CITY OF ALBUQUERQUE

Re: McDonalds – McMahon Marketplace - 5700 McMahon Blvd. NW
Erosion Sediment Control (ESC) Plan
Engineer's Stamp Date 3/20/2014 Sheet C3.0
Engineer's Stamp Date 2/21/2014 Sheet C3.1 (A11/E011B)

Based upon your submittal received 3-24-14, the above referenced Erosion Sediment Control (ESC) plan is acceptable for Building Permit based on the following condition:

**C3.1**

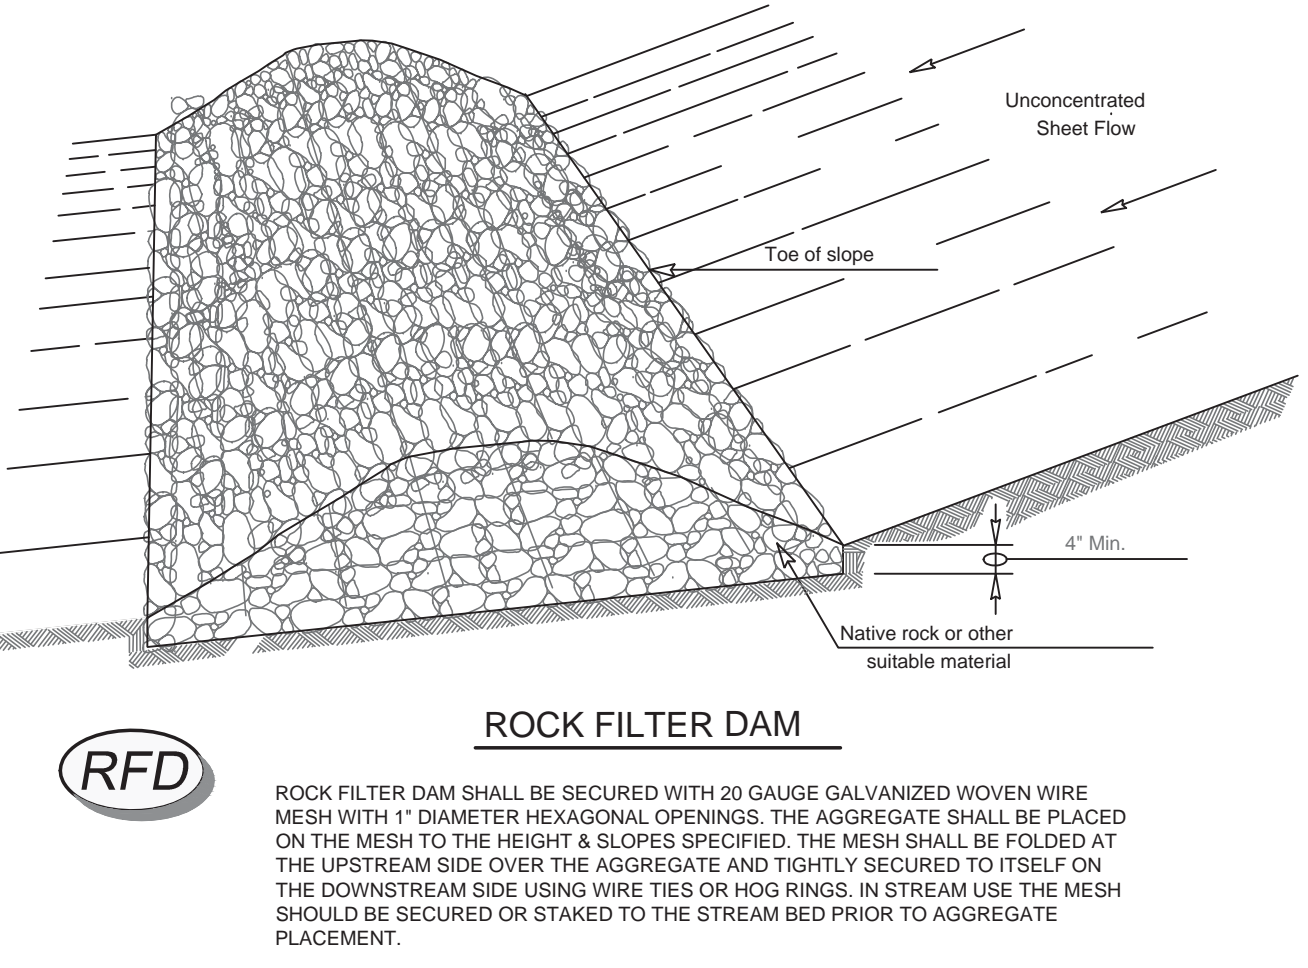
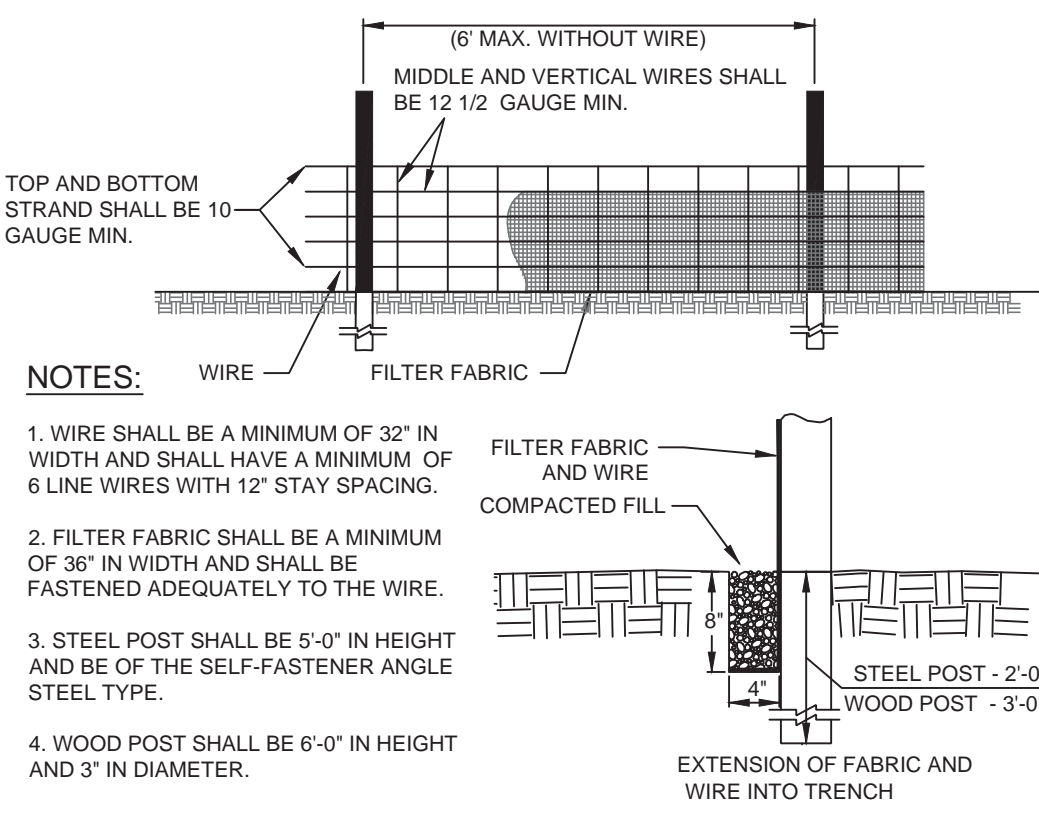
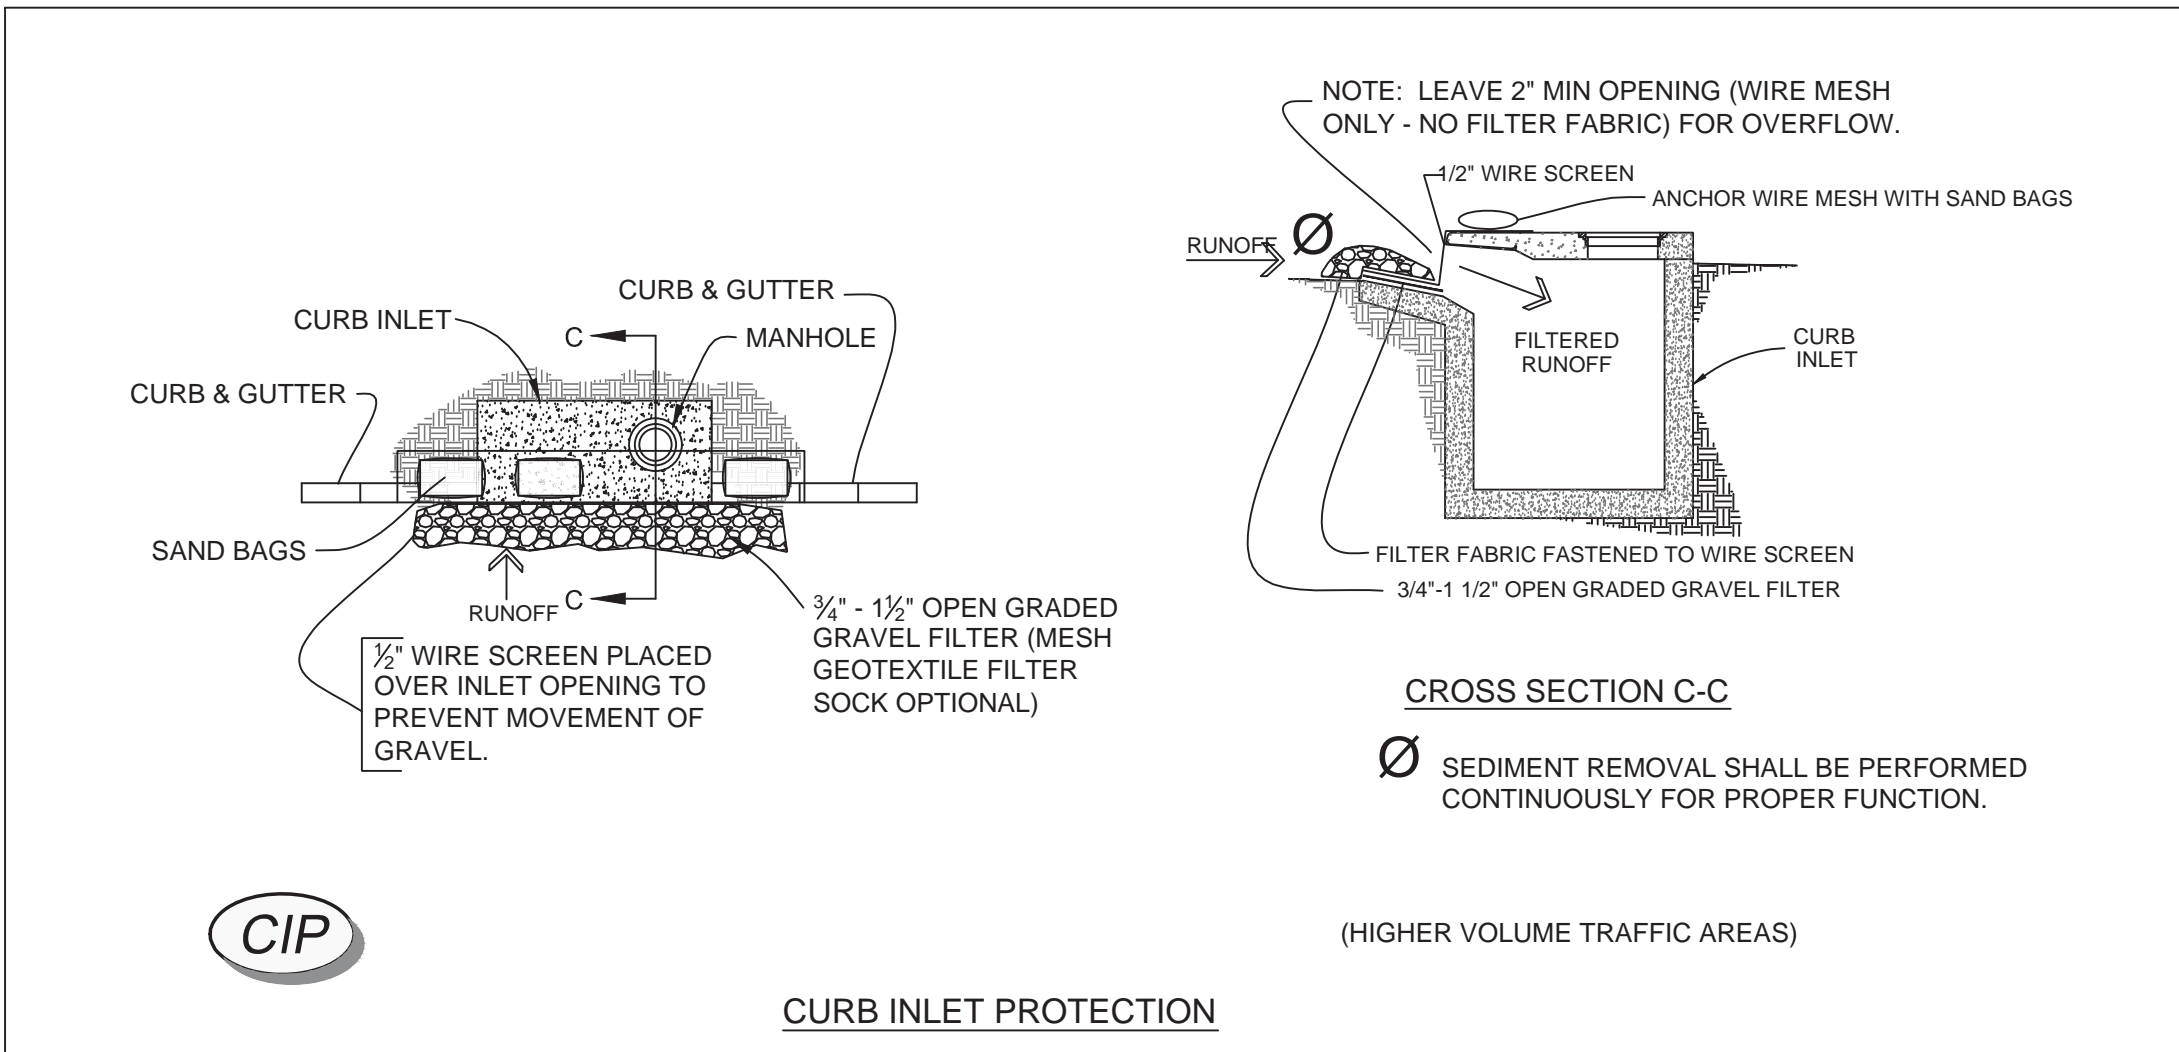
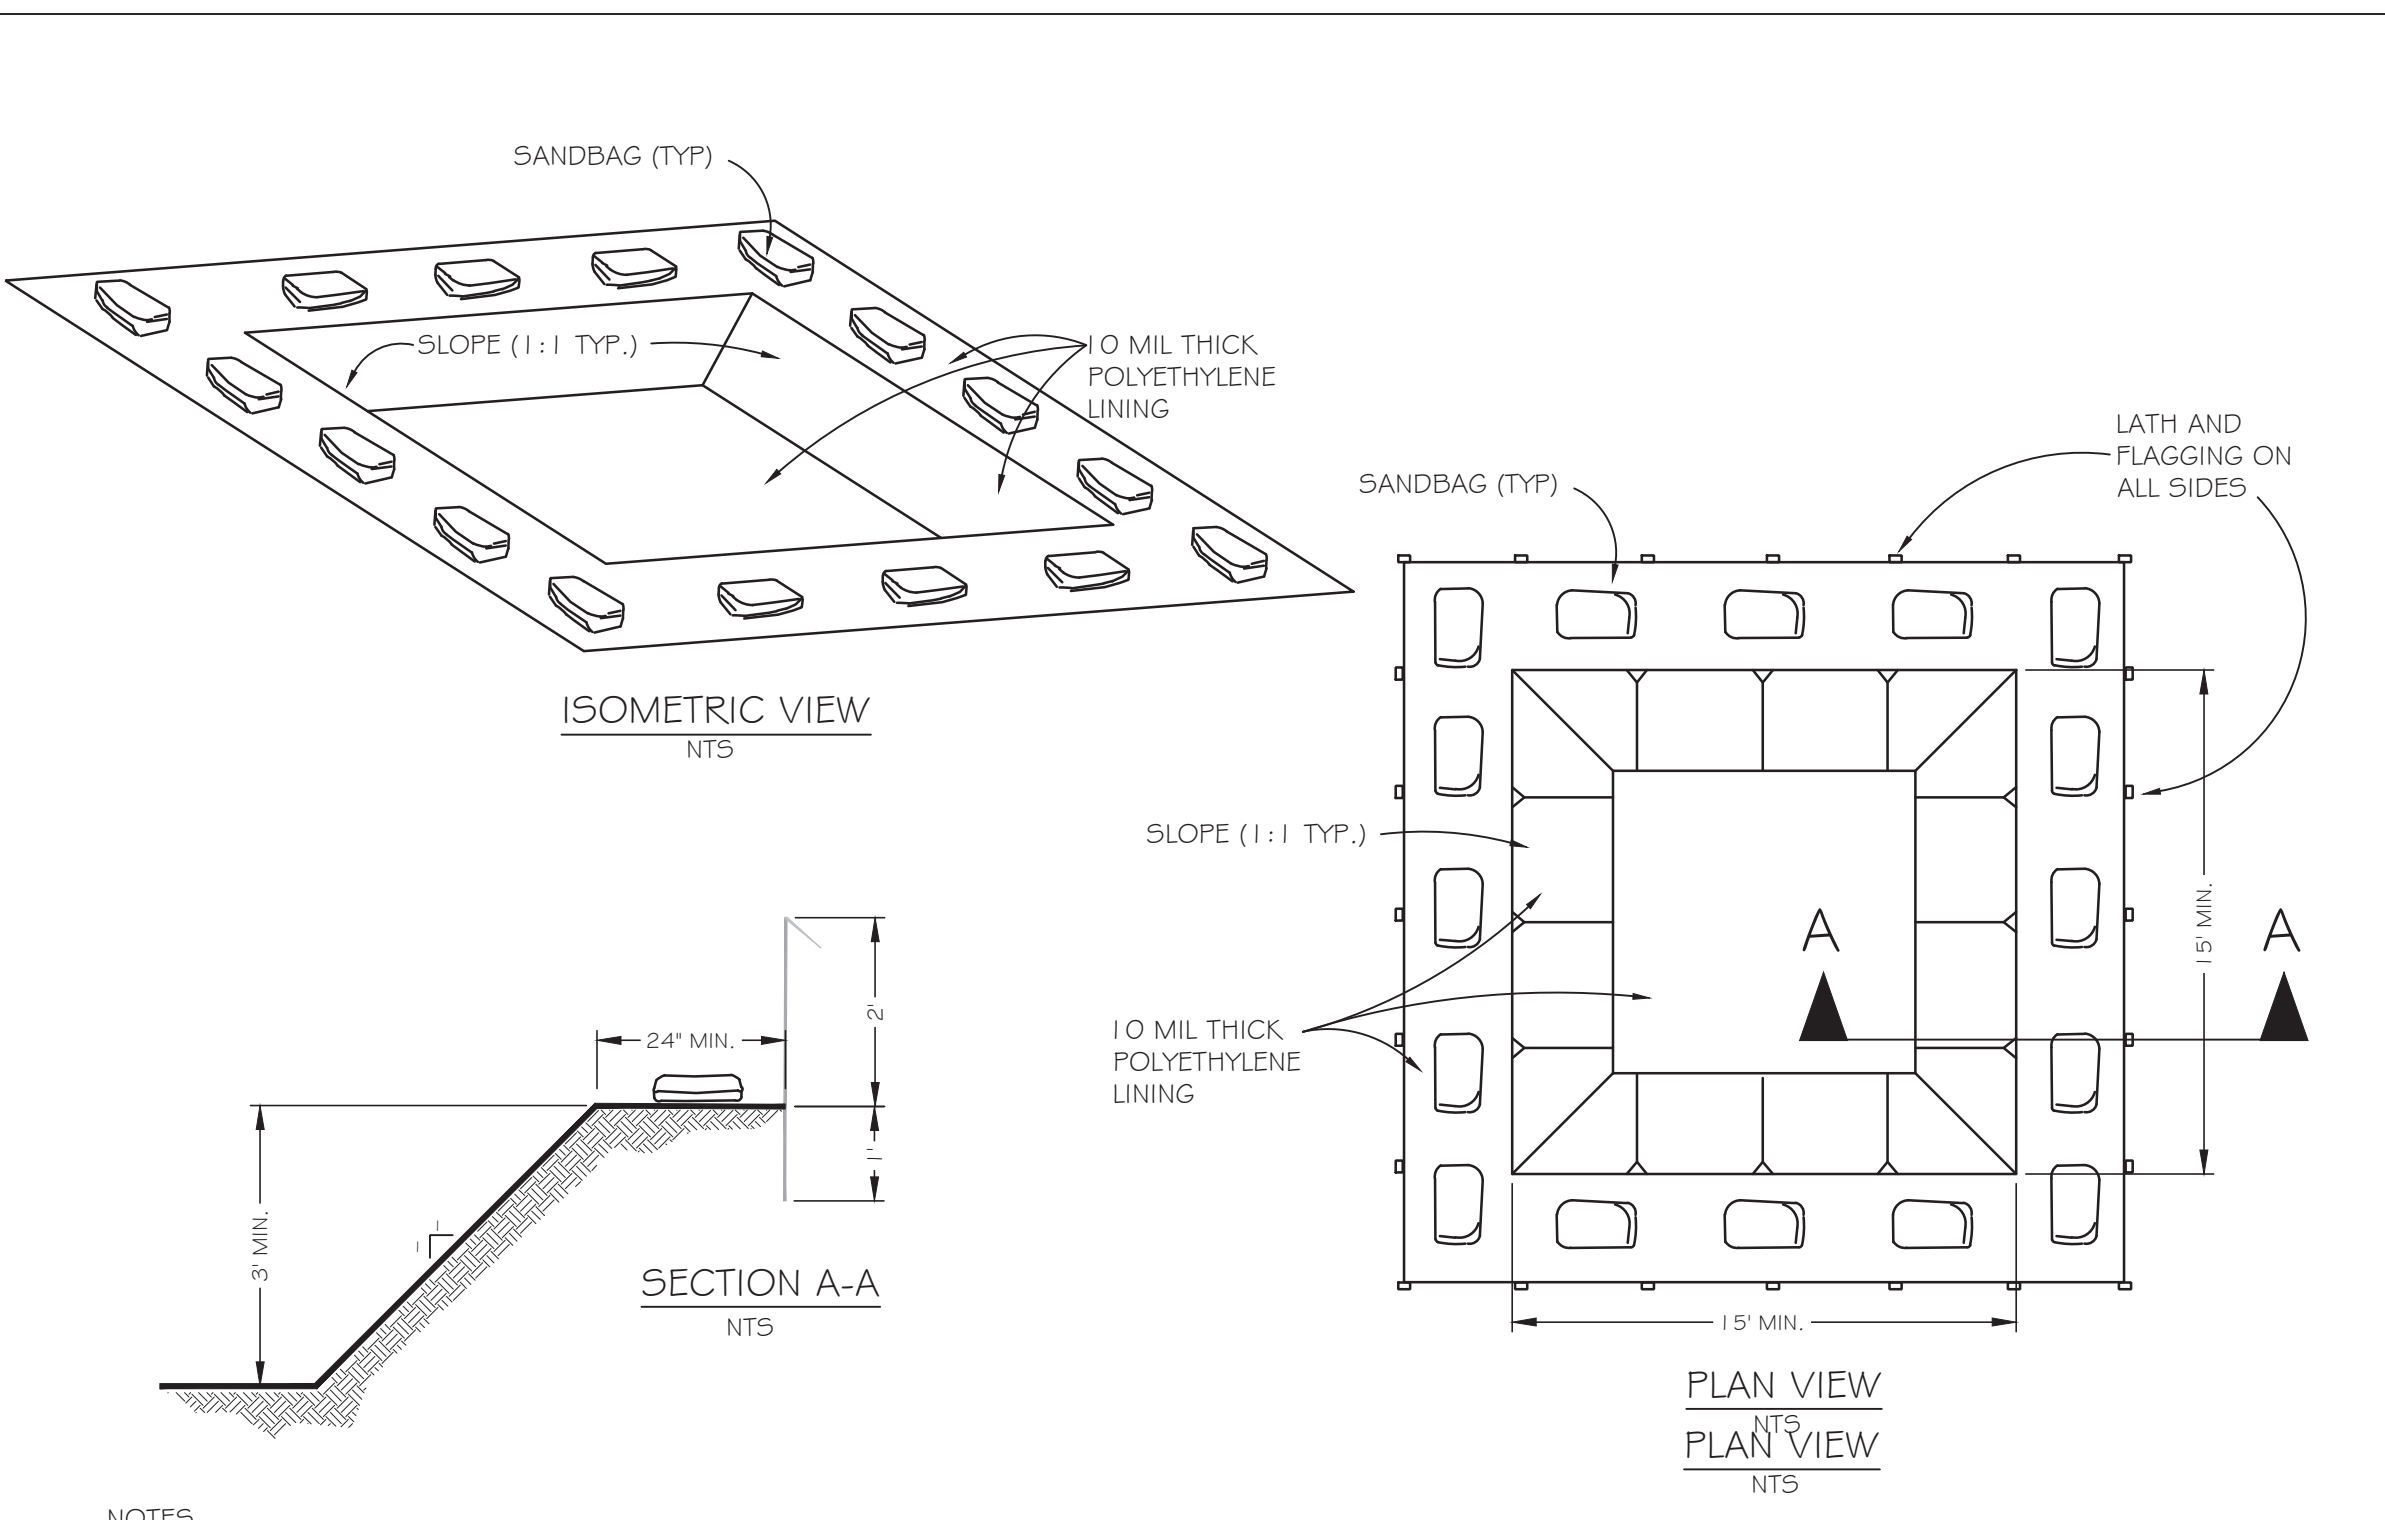
_ NPDES Posting Board should be visible from public sidewalk or street.
